File No. : CMDA/PP/NHRB/N/1053/2019

Sub:CMDA – Area Plans Unit - 'B' Channel (North) - Planning Permission Application is for the proposed construction of Stilt+ 4 Floors Service Apartment (18 Flats) at Door No.4, New Door No.18, Bharathi Road, Perambur, Chennai – 11. Comprised in T.S.No.434/16, Block No.23 of Perambur Village Remittance of DC & Other charges – DC advice Sent –

Proposed Rain Water Harvesting System Provided as per CBR Norms Drawing No.3A Not To Scale

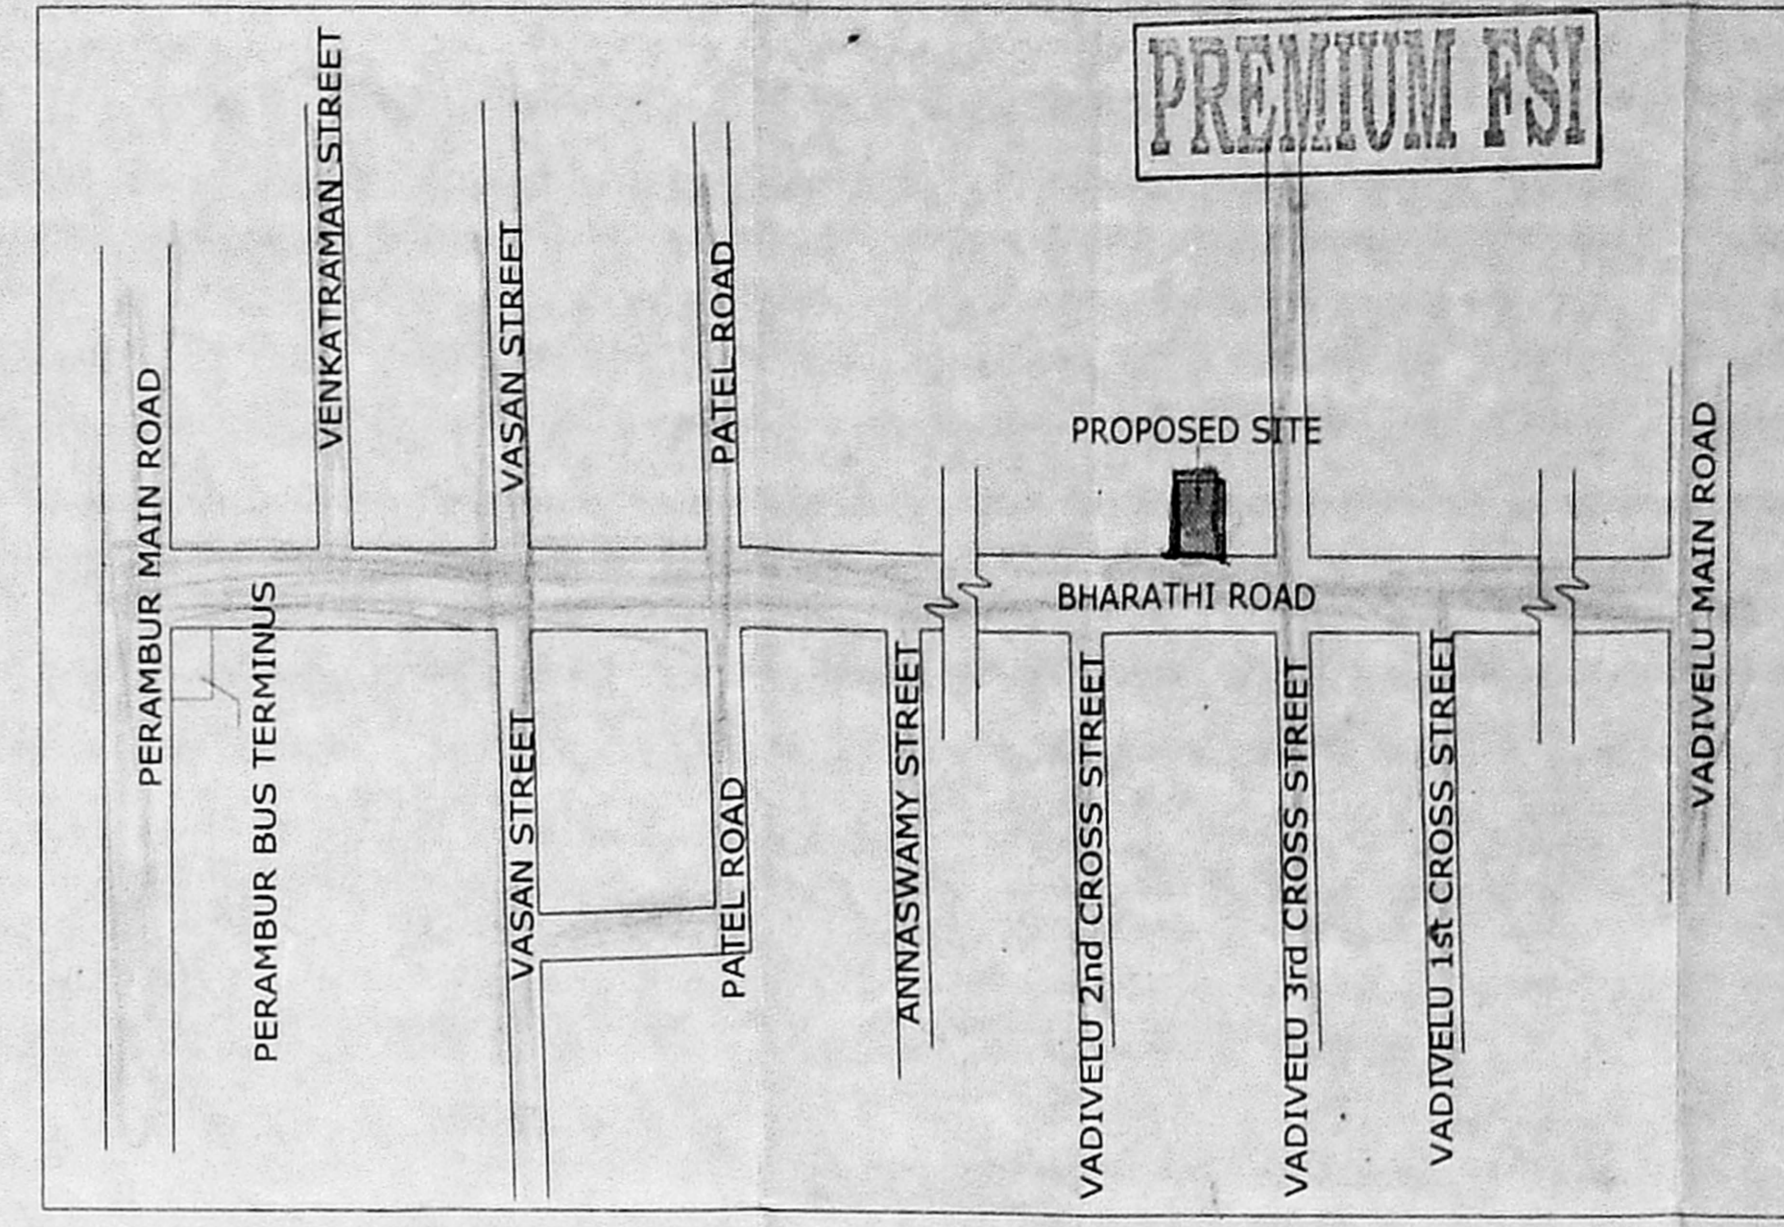
- Area statement and title of the plan requires correction
- Bedroom to be Rename as Living
- Building overall height to be shown in Section / Elevation
- Sufficient 1/3 rd area to be provided for solar photo voltaic system
- Rain Water Harvesting to be Provided as per TNCDDBR
- 5 Copies of Revised plan rectifying the above correction
